BLACK HILLS ENERGY SQUIRREL CREEK - 8" GAS MAIN

CITY OF FOUNTAIN AND EL PASO COUNTY, COLORADO

BLACK HILLS ENERGY - SQUIRREL CREEK
GRADING AND EROSION CONTROL PLANS
GEC COVER SHEET

PROJECT NO.
096826014

JOSHUA PALMER, P.E. COUNTY ENGINEER
DATE

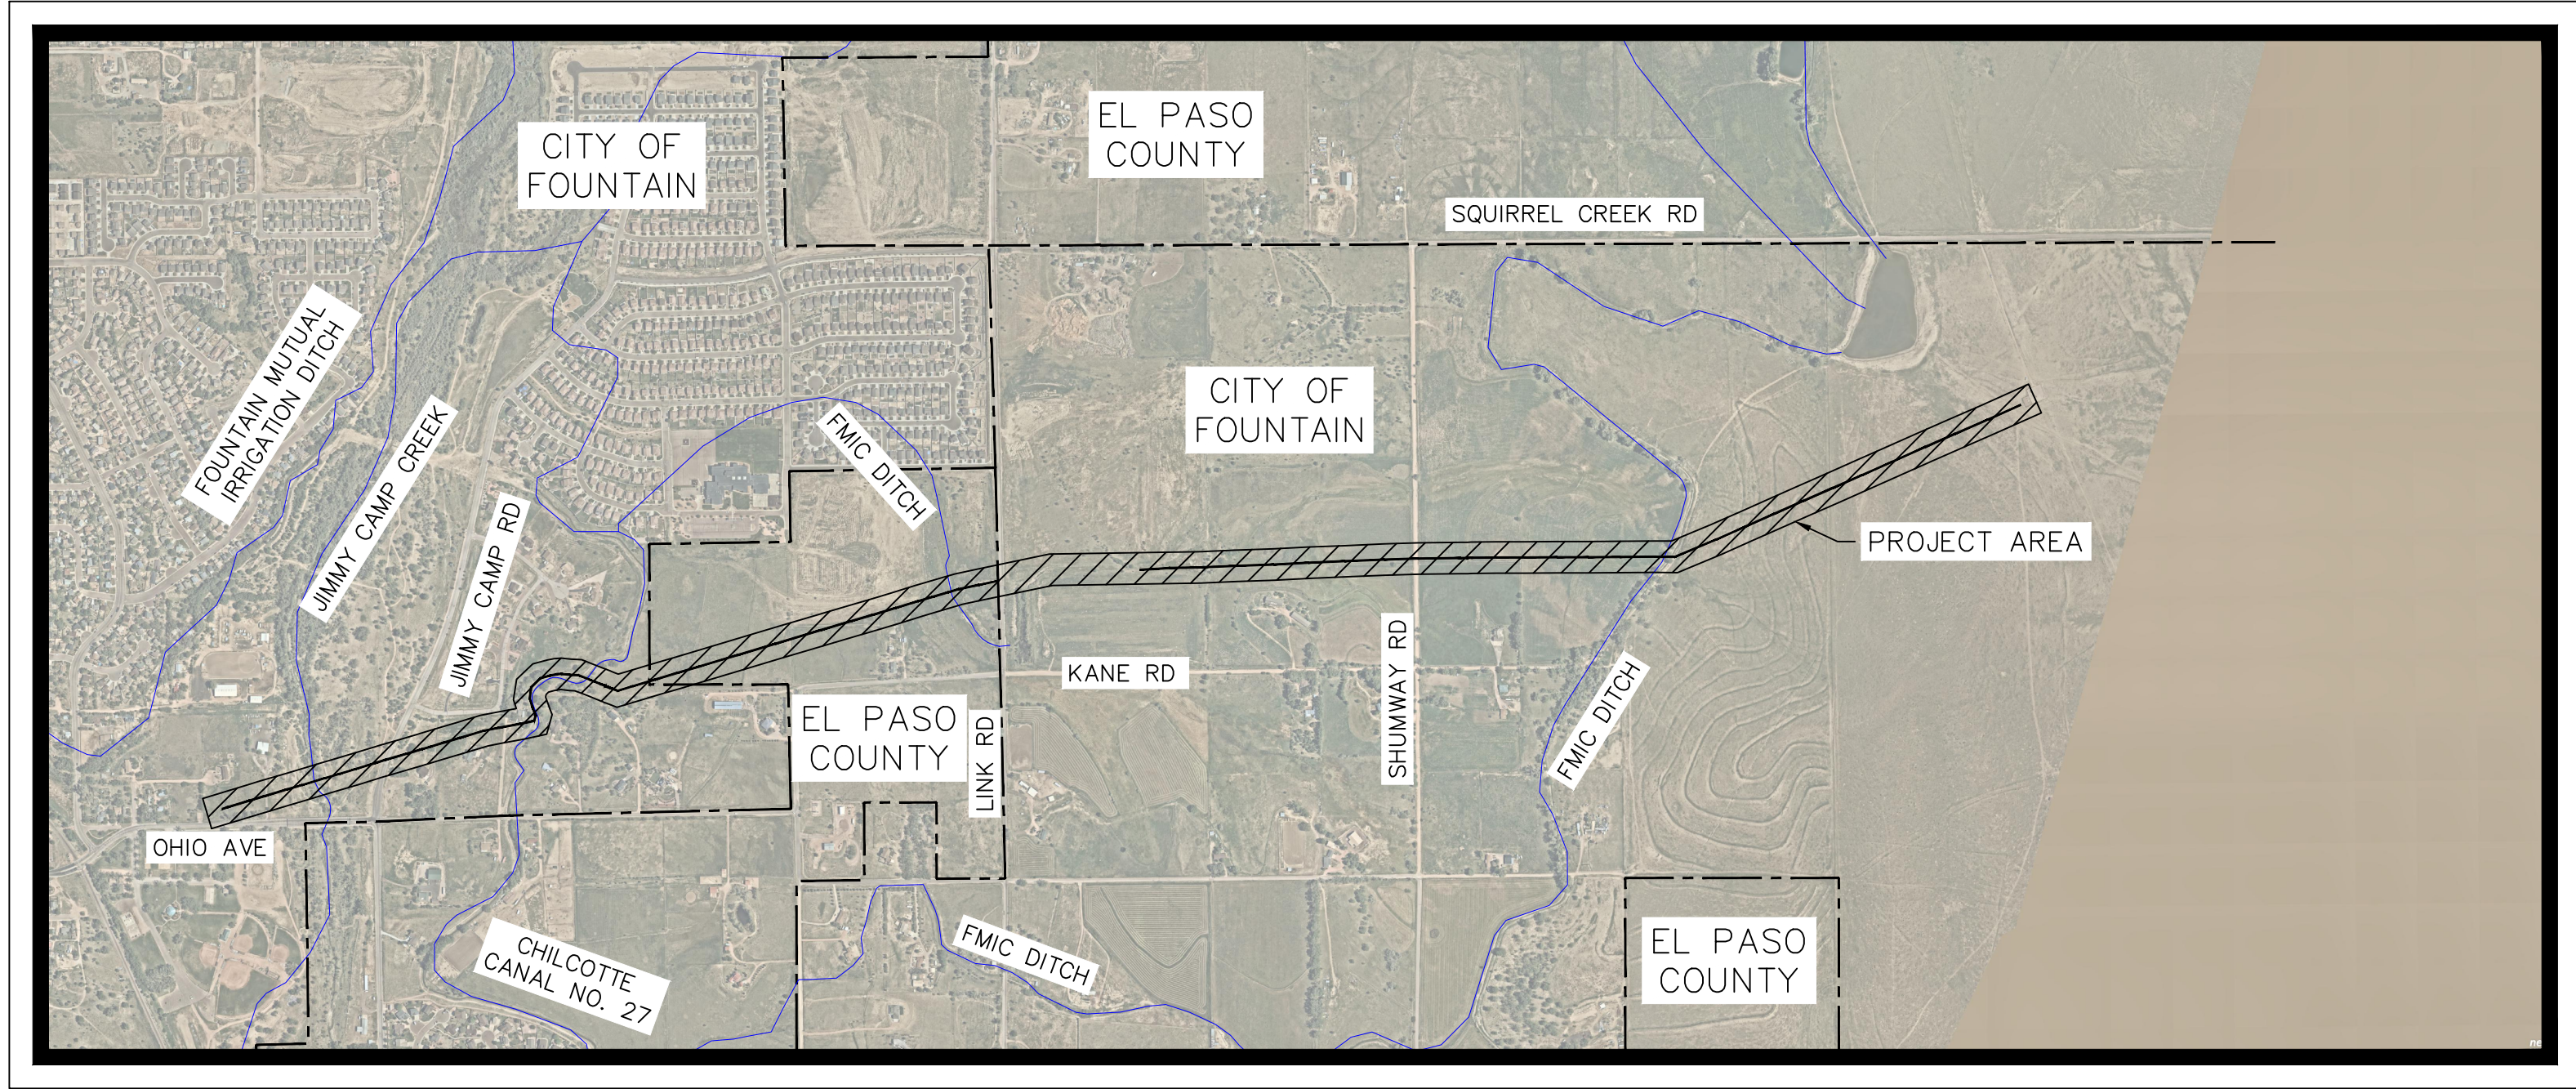
Revise signature block to county standard

Revise text to match GEC Checklist Item "ff" since this is a standalone GEC Planset

INITIAL (INTERIM) PHASE - 1

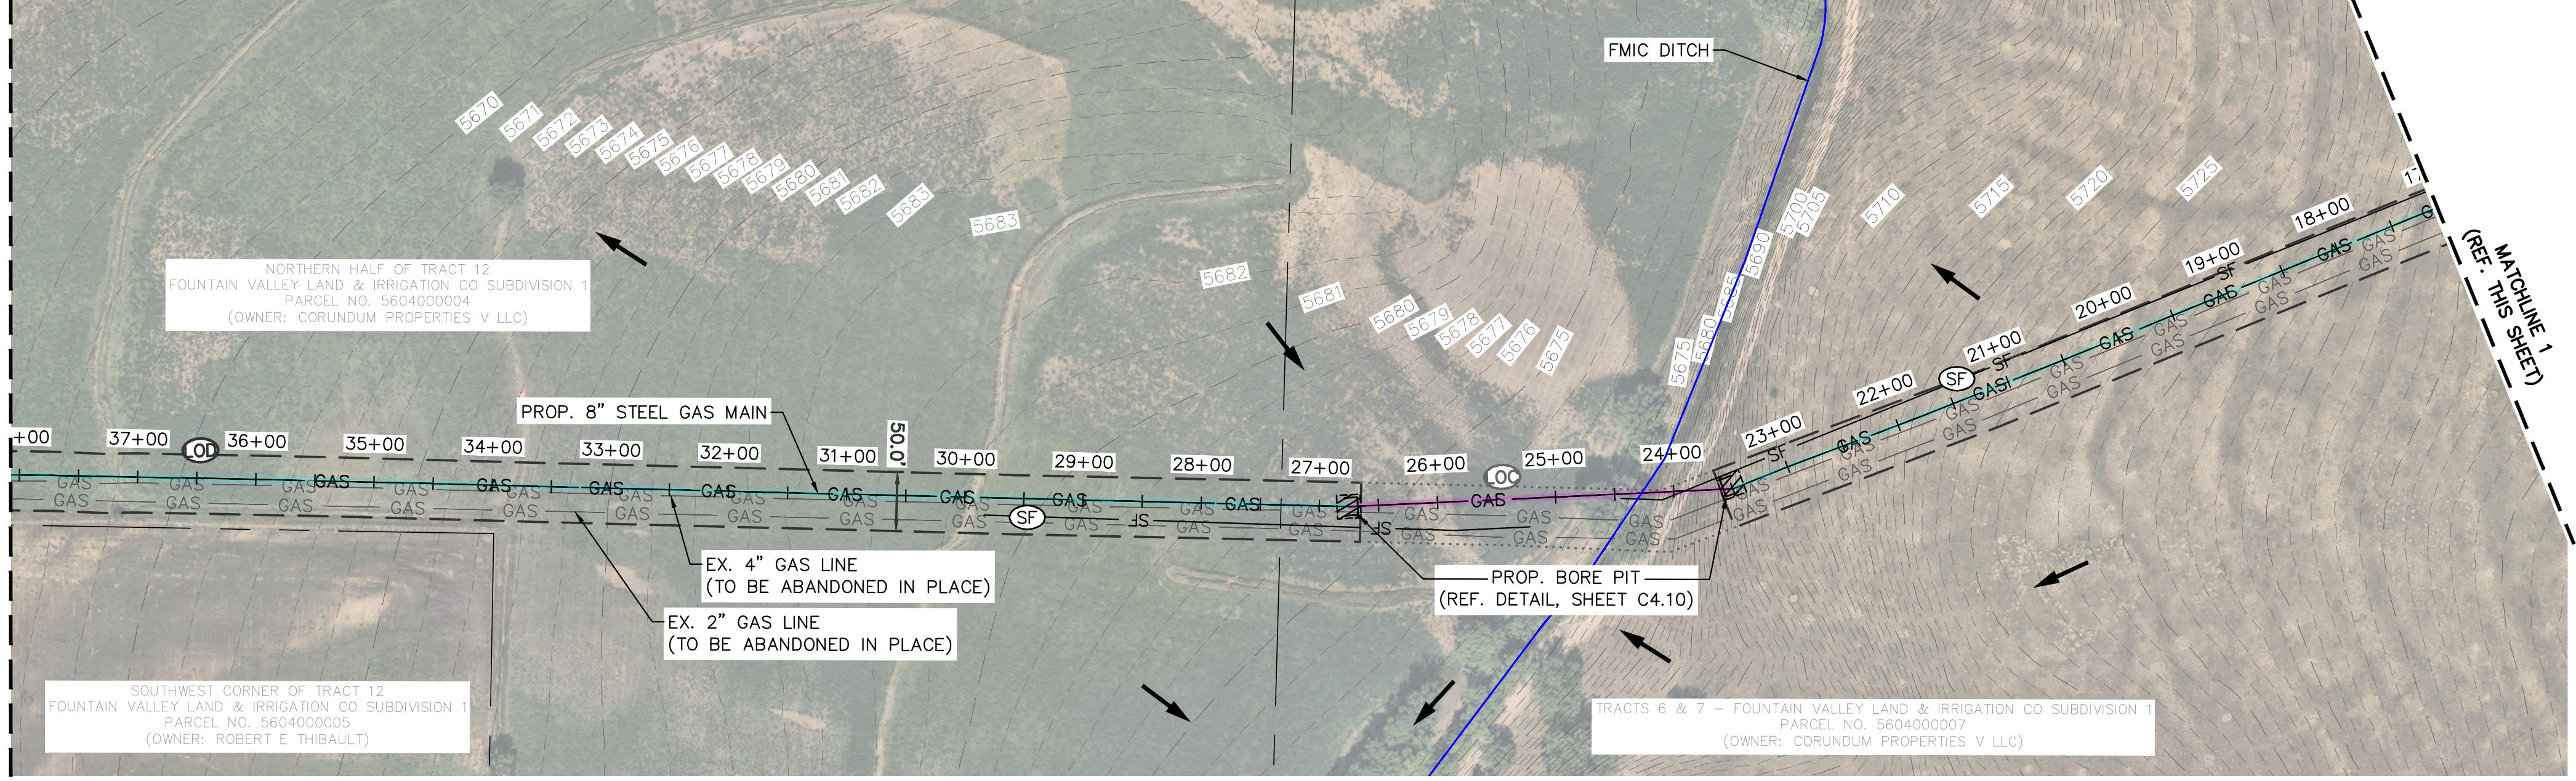
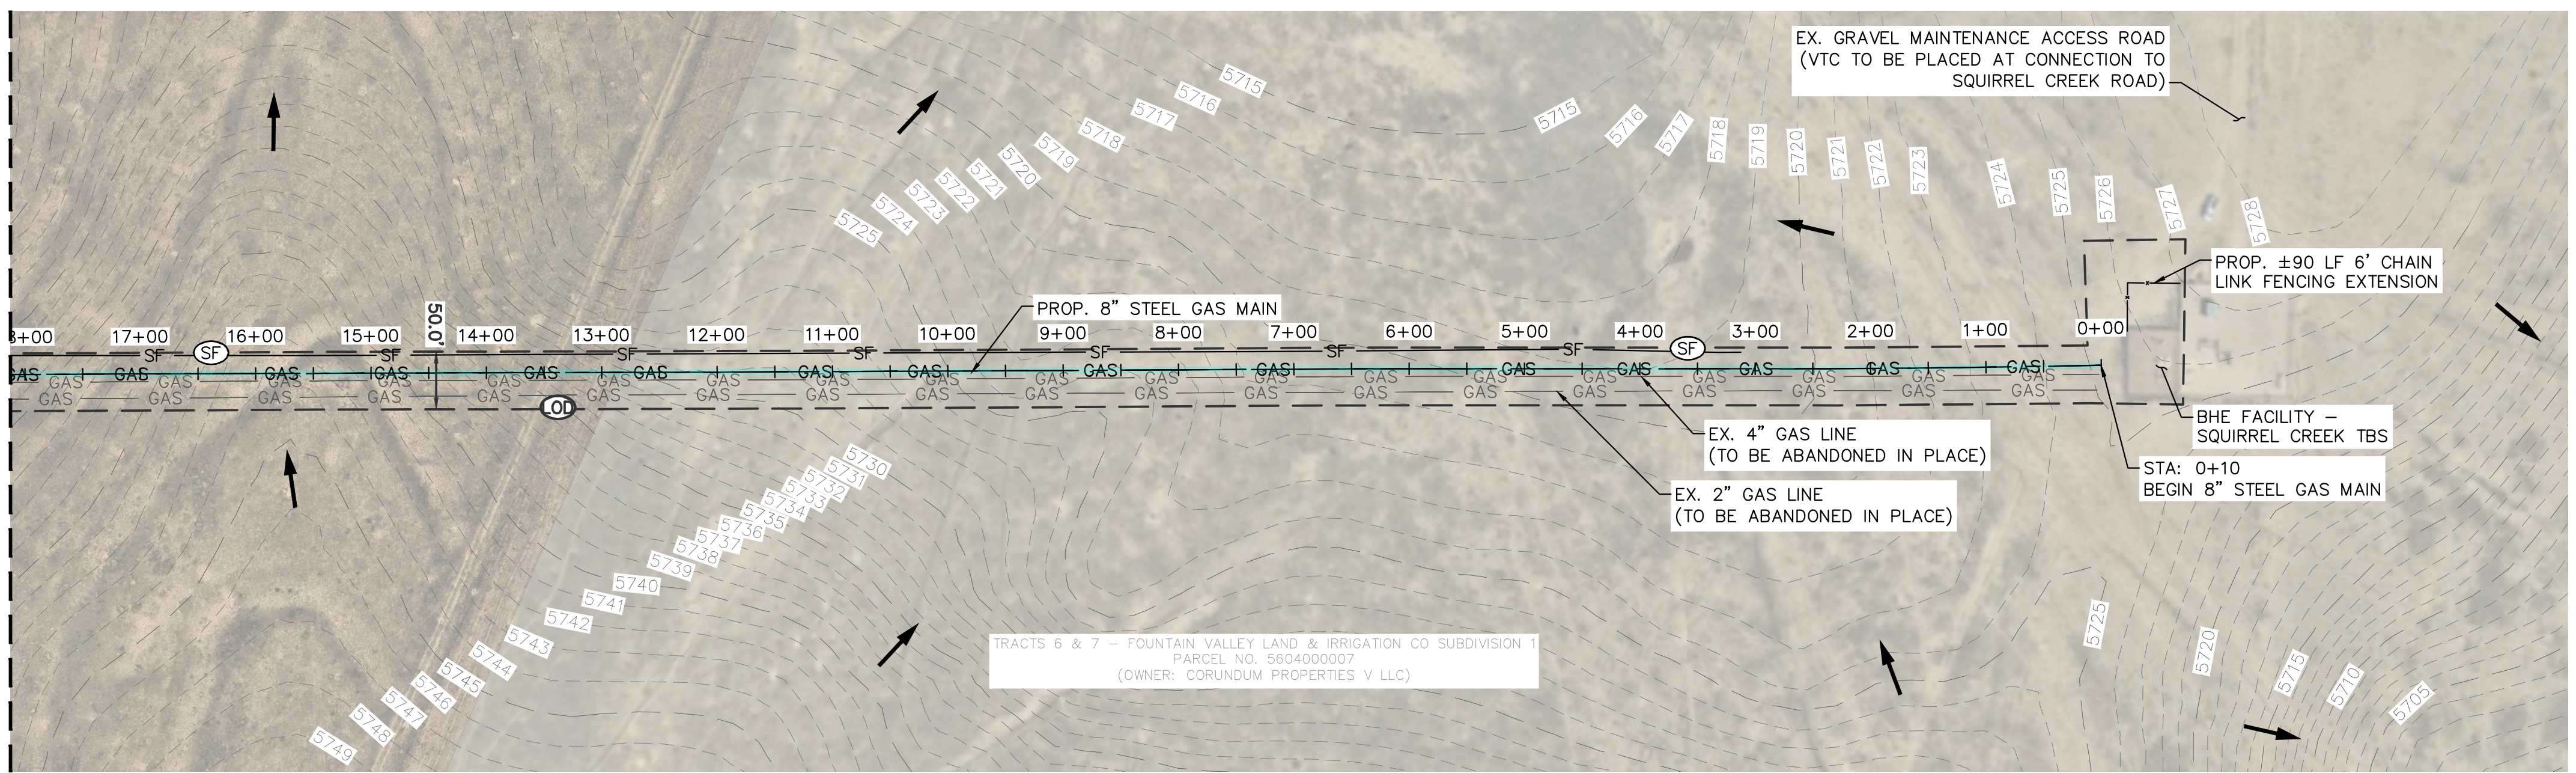
Label all proposed temporary construction BMPs by phase of implementation (initial, interim, final).
